Office of Environment & Heritage

Your reference : Crookwell 3 Wind farm
(MP10_0034)
Our reference : DOC12/44804
Contact : Martin Henery (02) 62297062

RE: Exhibited Environmental Assessment for Crookwell III Wind Farm (MP 10_0034)

Attachment 1: OEH detailed comments on the Environmental Assessment for Crookwell III Wind farm (MP10_0034)

Figure 3: Proposed Site Layout – Crookwell 3 Wind Farm

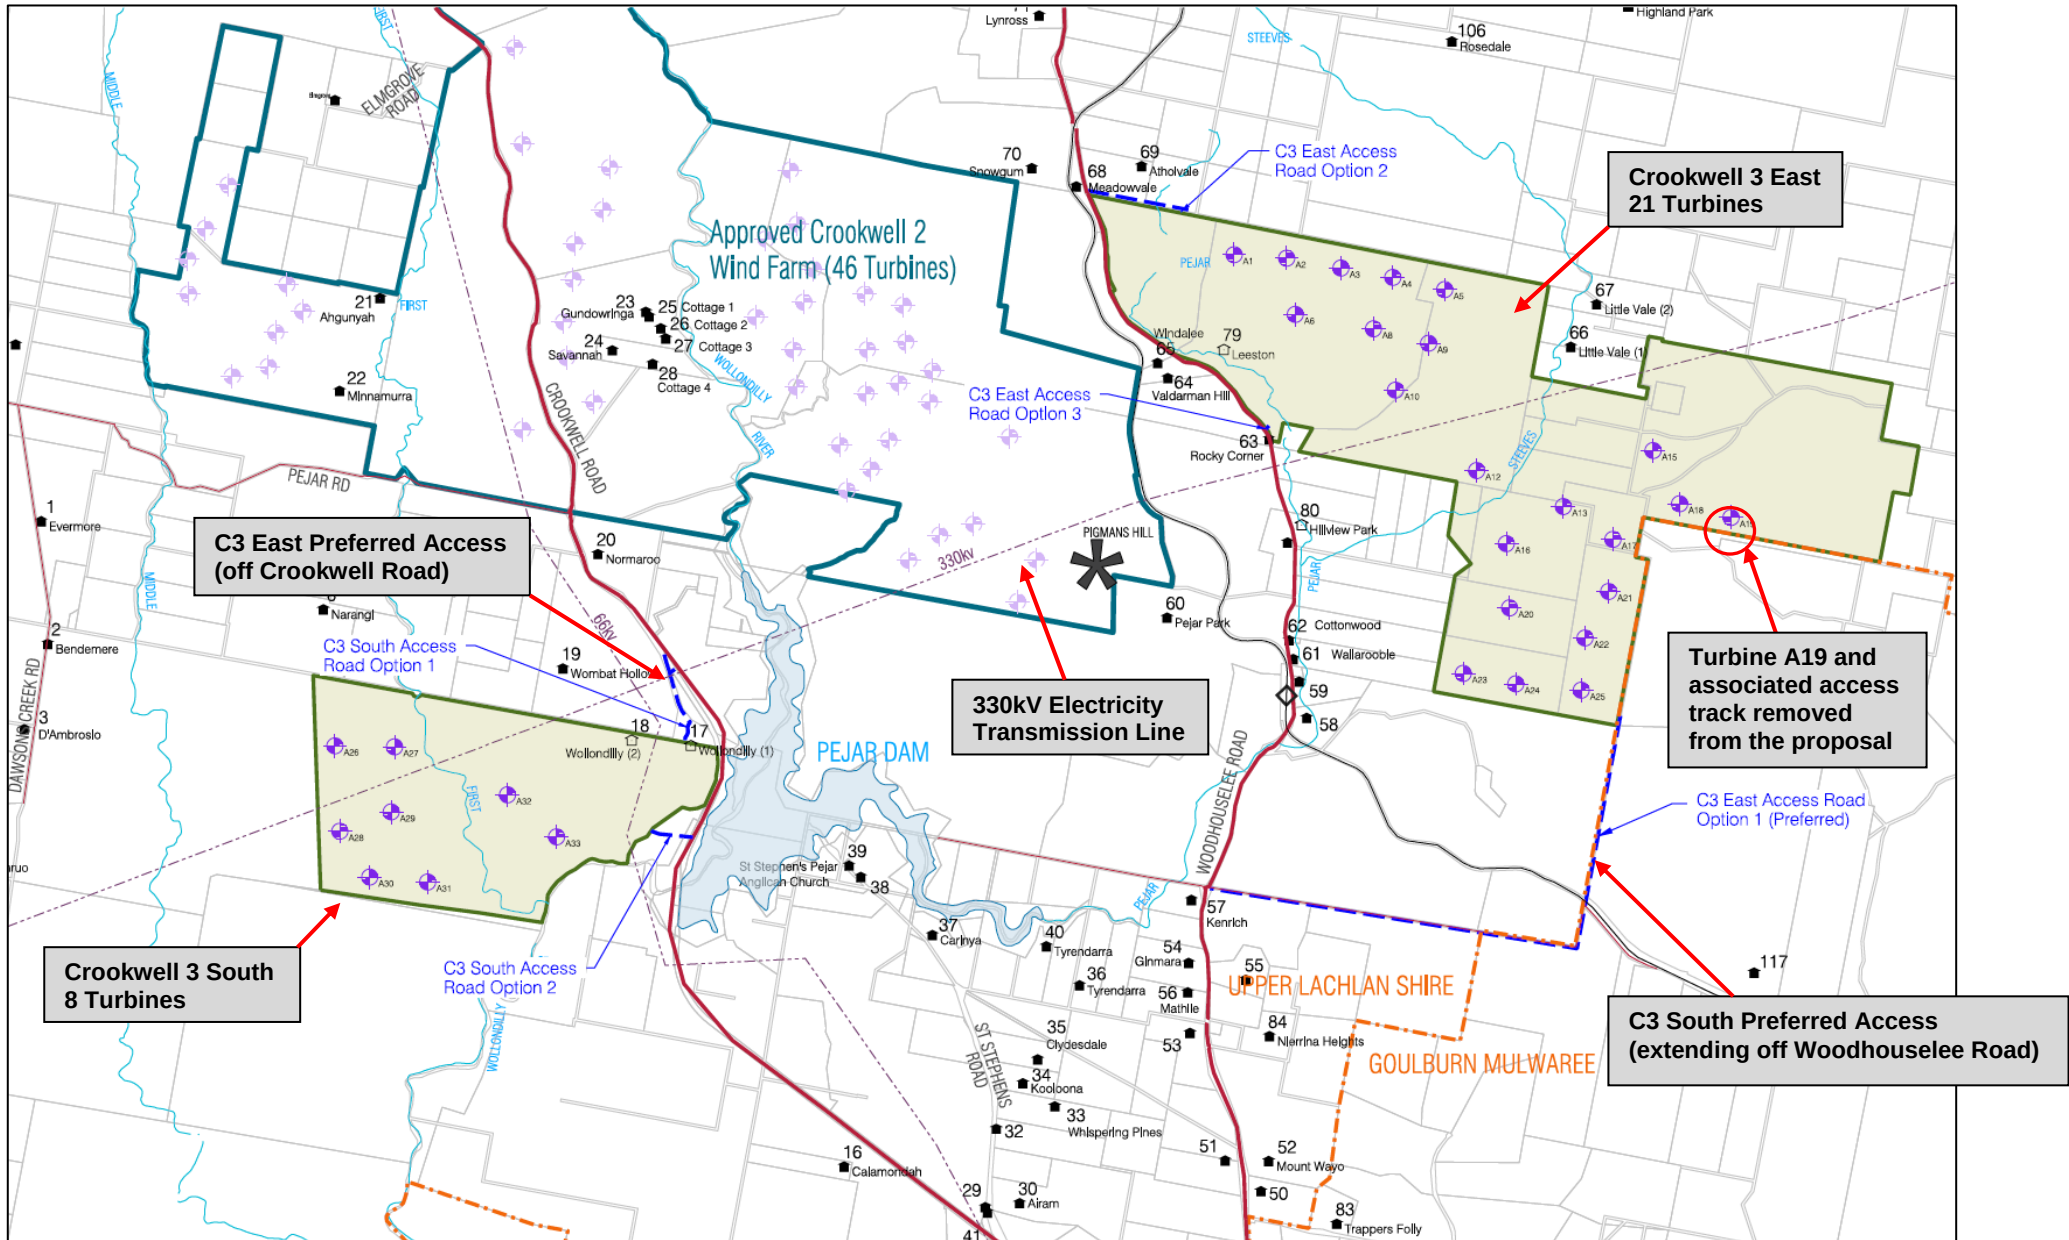
- OEH does not support the location of turbines within remnant woodland or forest, particularly in large remnant patches in otherwise cleared and fragmented rural landscapes. Of primary concern to OEH is the location of turbines A12, A18 and A19 within large remnants. Turbines A18 & A19, in particular, are proposed to be located in a vegetation type that has been 90% cleared, i.e., an over-cleared vegetation type, the clearing of which would not be supported under either the Property Vegetation Plan (PVP) tool or BioBanking Assessment Methodology (BBAM). Medium sized remnants in heavily cleared rural landscapes, such as the area proposed for turbine A12, are likely to provide habitat for several threatened fauna species known occur in the region. It is the view of OEH that, given the inadequacies of the fauna survey, turbine A12 should also be removed from the design to minimise potential impacts on threatened species.

Given the inadequacies of the survey, OEH considers that it is appropriate to remove Turbines A12, A18 and A19 from the proposed project, as these are within larger and highest quality remnants where fauna are more likely to be impacted by construction and operation of turbines.

OEH therefore does not support the current project design, and recommend that it be amended to re-site or remove turbines A18 and A19 from within high conservation value remnant woodland.

However, as stated above, OEH does not support the location of turbines A12, A18 and A19 within large remnant patches of woody vegetation. If these are removed from the project proposal, no offsets may be required for losses of woody vegetation.

Figure 9: Proposed Turbines A18, A19 and Associated Access Tracks within Remnant Vegetation

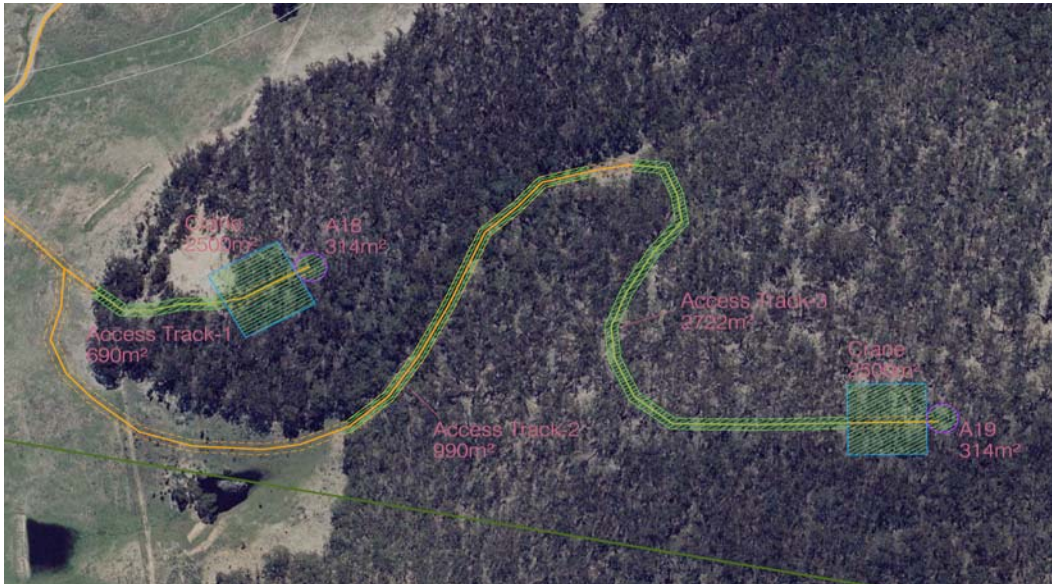
The proponent has not demonstrated that the first principle of 'avoidance' has been applied to the location of turbines across the landscape. The Flora and Fauna Assessment (Appendix 8 within the EA) classified the largest remnant on the site and the proposed location for turbines A18 and A19, as Western Tablelands Dry Forest according to Thomas et al. (2000). The site of the turbines, however, is dry sclerophyll forest with a canopy dominated by *Eucalyptus sieberi* and *E. dives* which the current Vegetation Types Database on the OEH website
